CITY OF ALBUQUERQUE

**Re: Masthead Office Phase II
Grading and Drainage Plan
Engineer's Stamp dated 10-1-12 (D17/D003P1)**

**Re: Masthead Office Phase II
Grading and Drainage Plan
Engineer's Stamp dated 9-24-12 (D17/D003P1)**

Grading and Drainage Plan

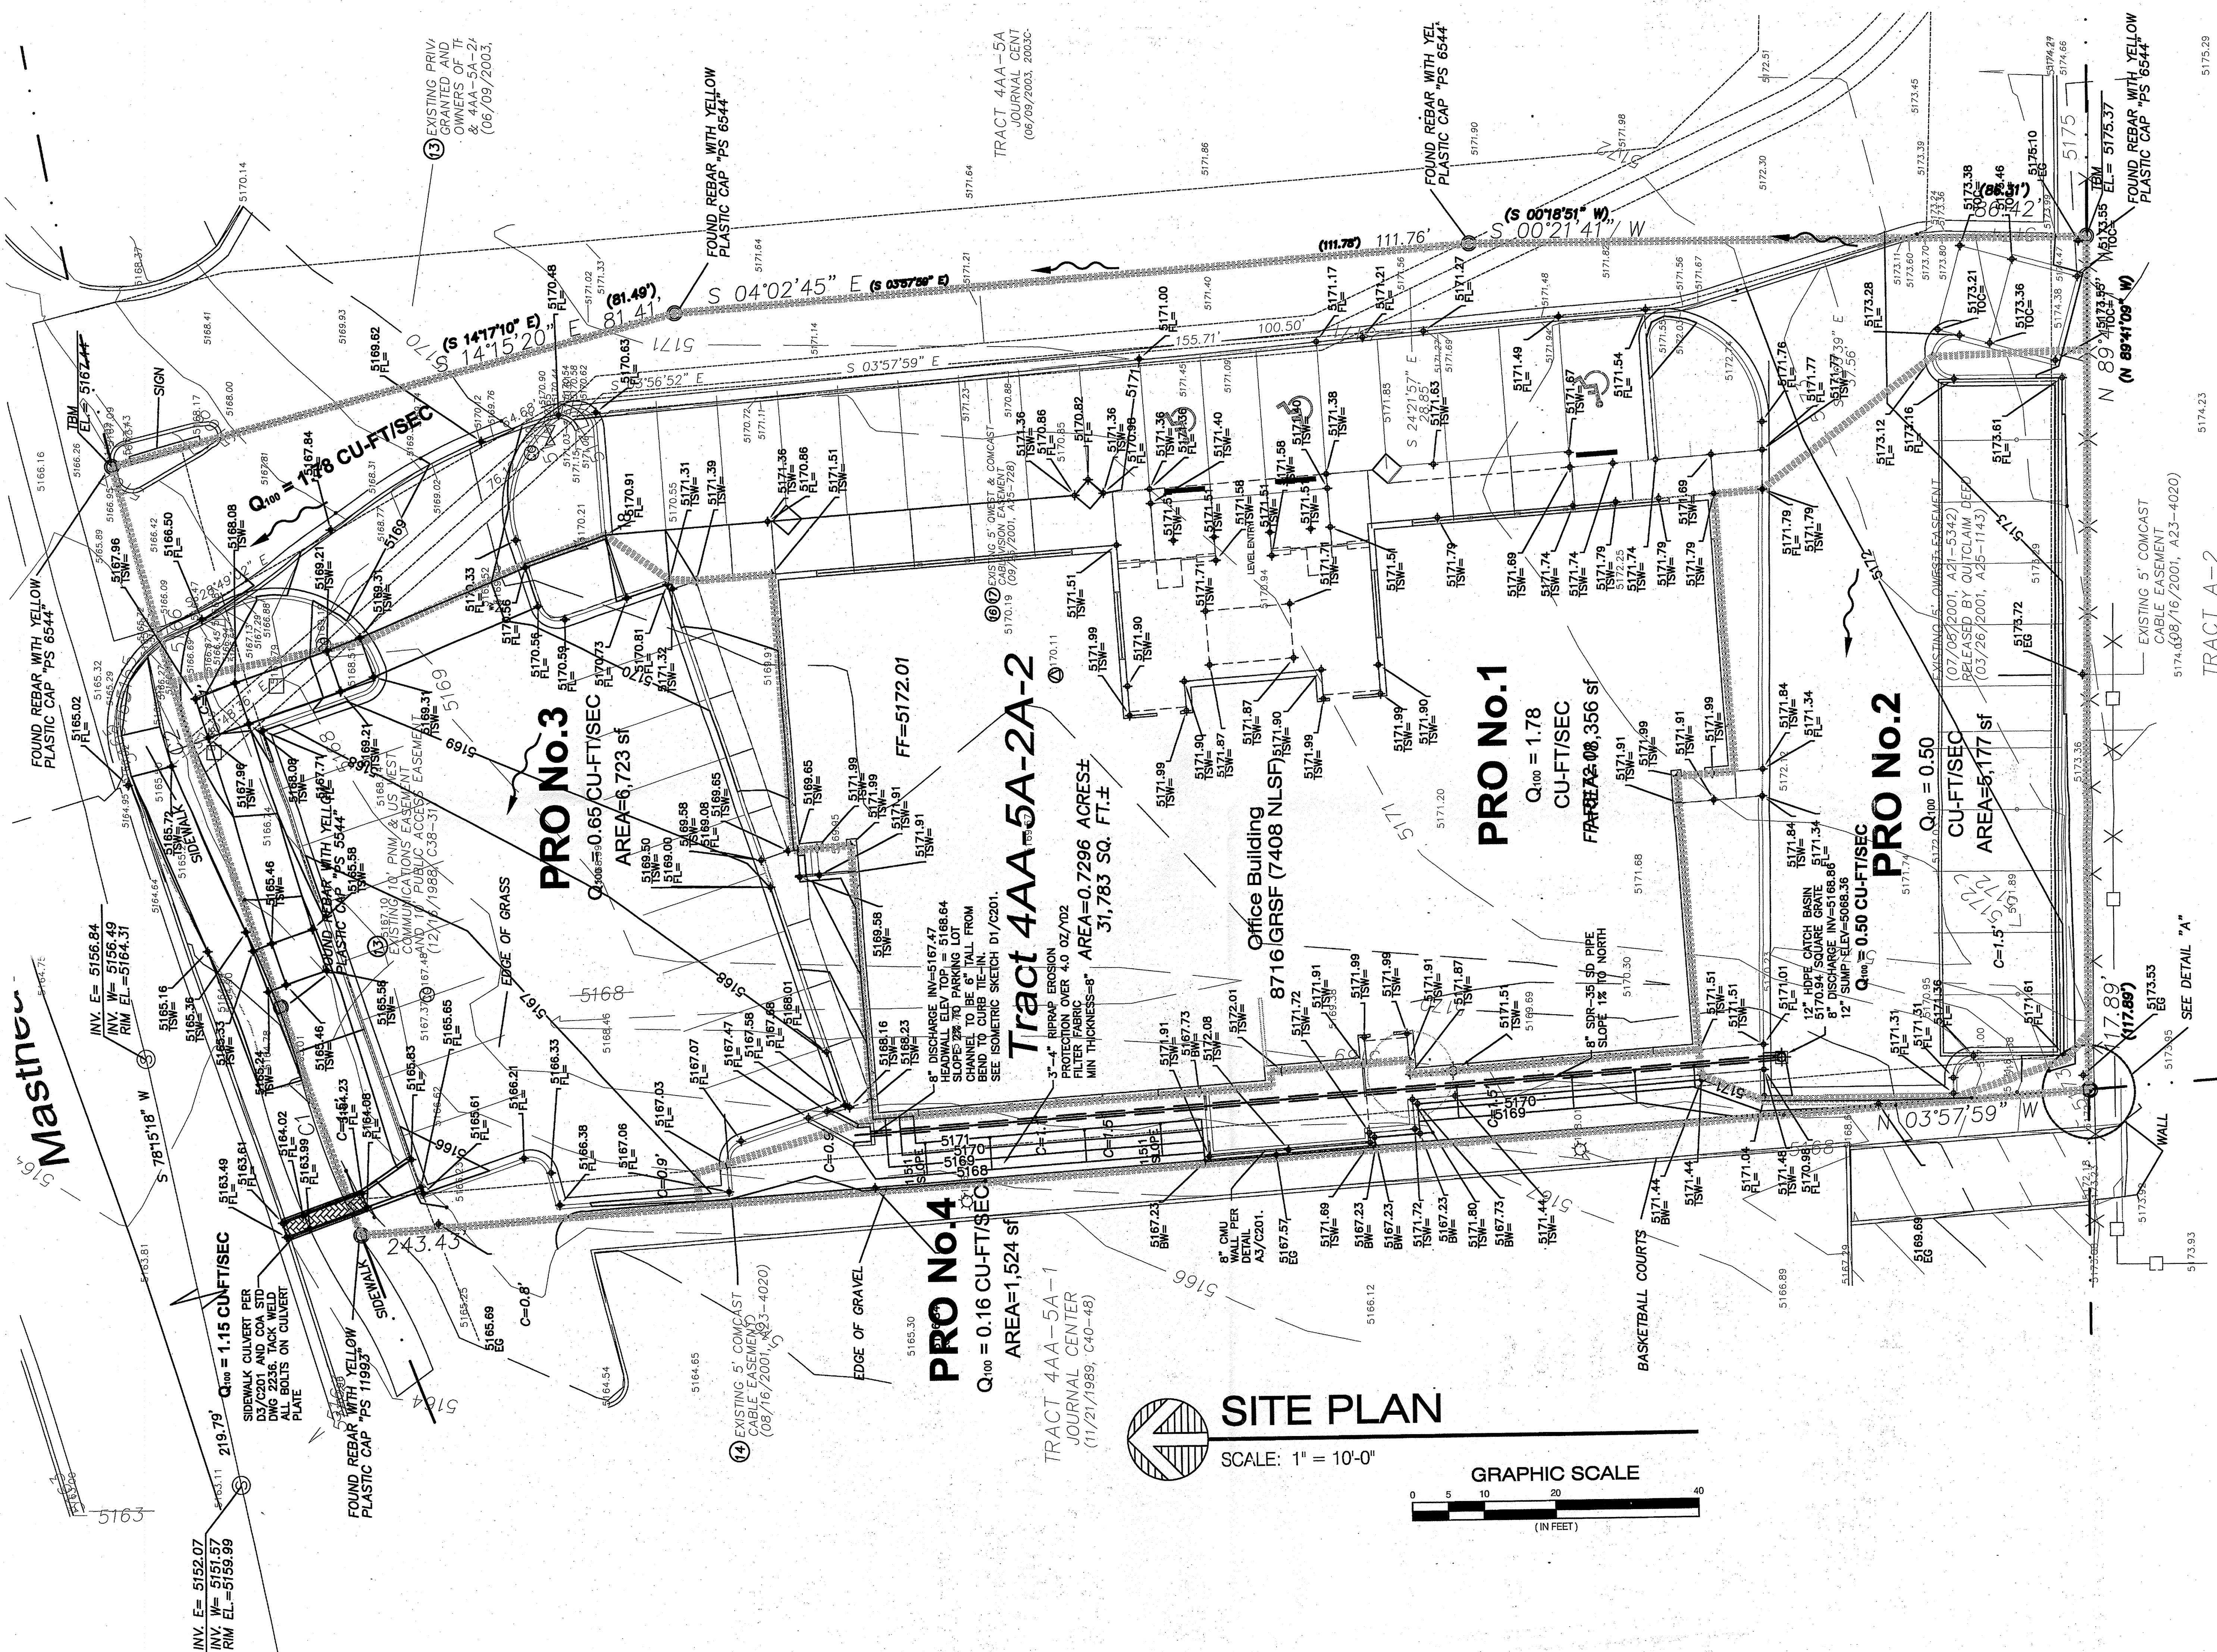
- Is there 3 or 4 drainage basins?
- The Drainage summary font is too small and not legible, increase the size and clarity.
- Under Prep 4 there is 105% land treatments.
- Site plan is not clear, enlarge.
- Depress all landscaping.
- Extend sidewalk culvert plate 2 feet past the property line.
- Tack weld all bolts on the sidewalk culvert plate.
- Show spot elevations along the property lines.

- Is there 3 or 4 drainage basins? *4 Corrected in narrative.*
- The Drainage summary font is too small and not legible, increase the size and clarity. *changed to 1/2" tall.*
- Under Prep 4 there is 105% land treatments. *Corrected.*
- Site plan is not clear, enlarge. *Created two additional sheets to show enough detail.*
- Depress all landscaping. *Gen Note Added.*
- Extend sidewalk culvert plate 2 feet past the property line. *Plate extended.*
- Tack weld all bolts on the sidewalk culvert plate. *Note Added.*
- Show spot elevations along the property lines. *Added.*
